**EXHIBITION OF ENVIRONMENTAL IMPACT STATEMENT  
PORT KEMBLA BULK LIQUIDS TERMINAL (SSD 15 7264)**

I am writing to provide comment on the Environmental Impact Statement (EIS) for the Bulk Liquids Terminal at Port Kembla (SSD 15\_7264) which was recently publicly exhibited.

Att A: Comments and additional information required

Figure 6.4: Annual and Seasonal Windroses for the Site (CALMET generated)

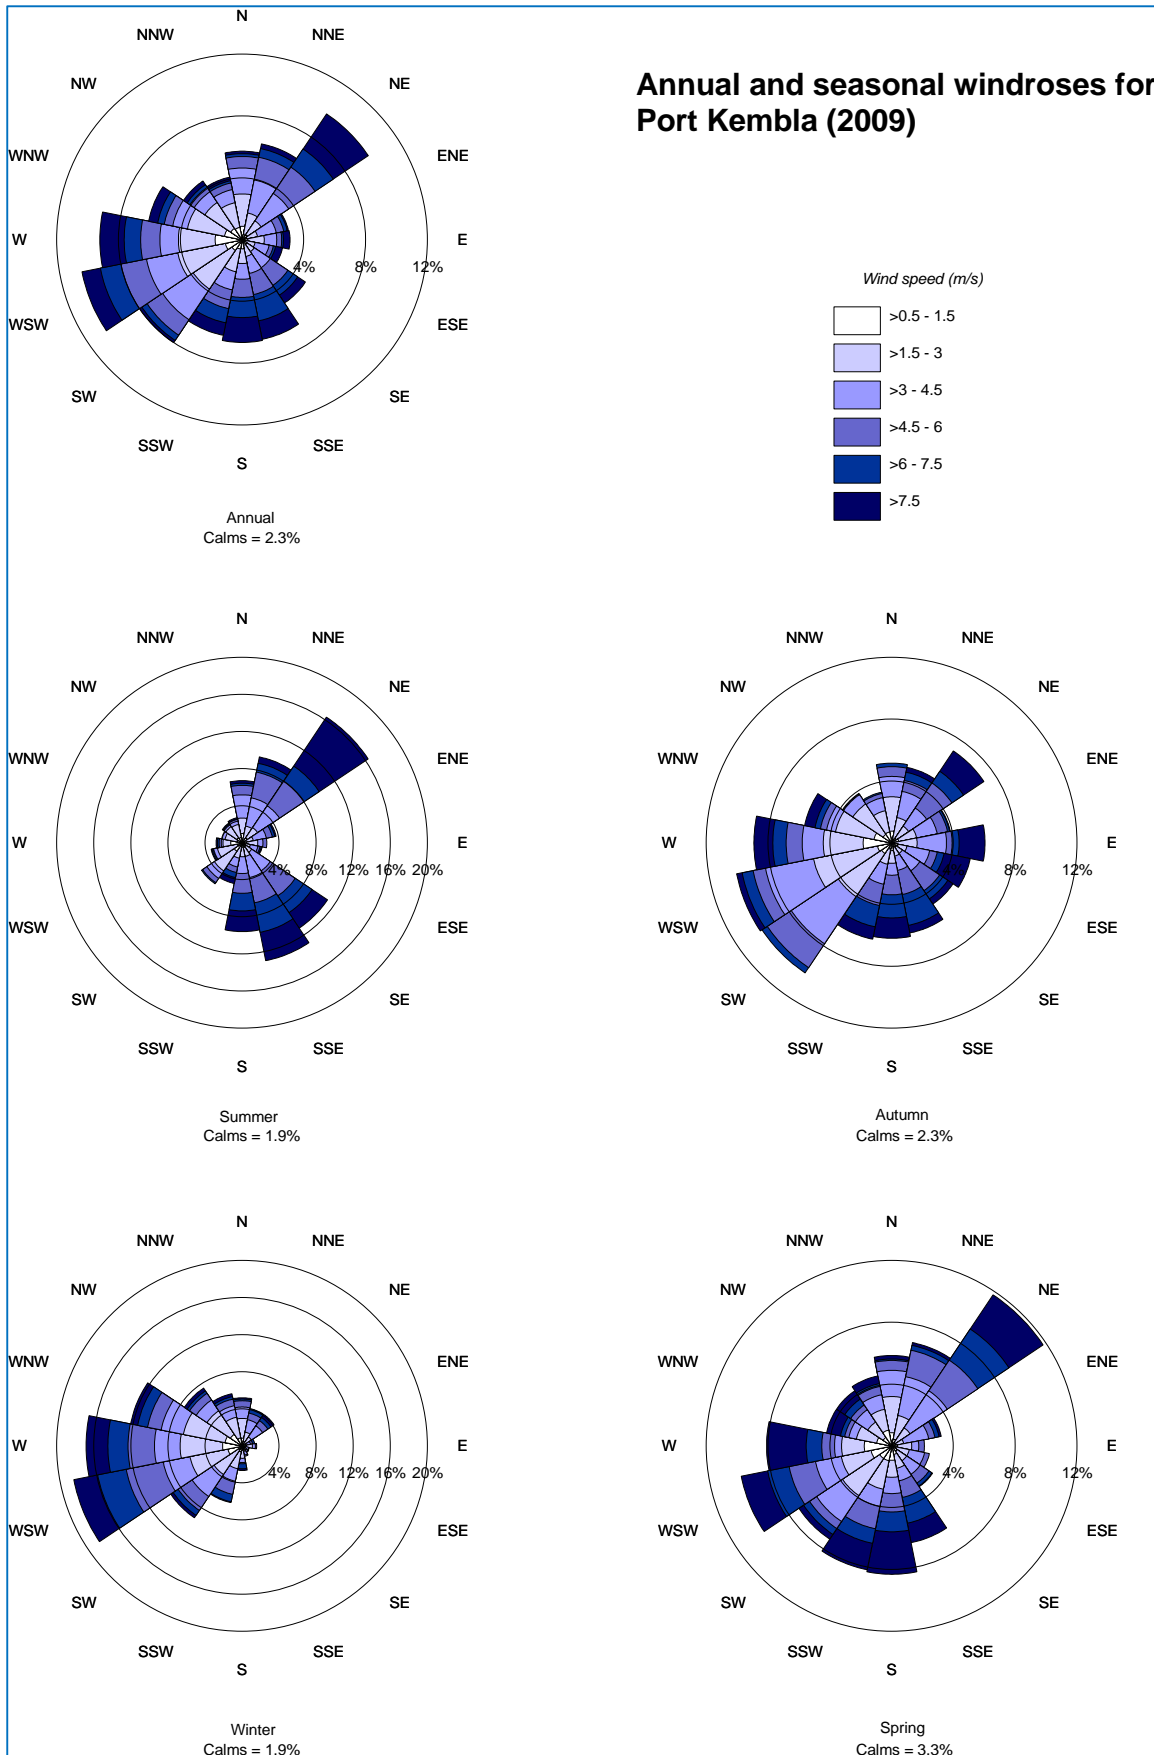
- 'Long term wind speed analysis of Bellambi monitoring site shows that wind speeds from the years 2008 and 2009 fitted best with the long term averages;' and
- 'It is noted that the Port Kembla Harbour automatic weather station (Site Number 68253) was commissioned post- 2009 and as such, this data was not able to be incorporated within the meteorological modelling. However, annual wind roses for this location compare well with the CALMET generated wind roses presented in Figure 6.4.'

The statistics as presented, do not confirm 2009 as a representative year for dispersion modelling. The EPA notes that the Port Kembla wind roses referred to in the report have not been provided. In addition, the statement that the 2008/2009 wind data best fits with long term averages is based on qualitative assessment alone.

Observed wind fields for Wollongong Airport are provided in the AQGGA as Appendix C. Observed wind fields for Port Kembla are not provided. Appendix C shows some potentially significant differences between modelled and observed wind fields. The AQGGA does not demonstrate the suitability of the CALMET generated data.

The AQGGA should be revised to include the results of the analysis demonstrating year 2009 is a representative year.

The AQGGA should be revised to include an evaluation of the CALMET generated meteorology data to demonstrate it is suitable for use in CALPUFF.
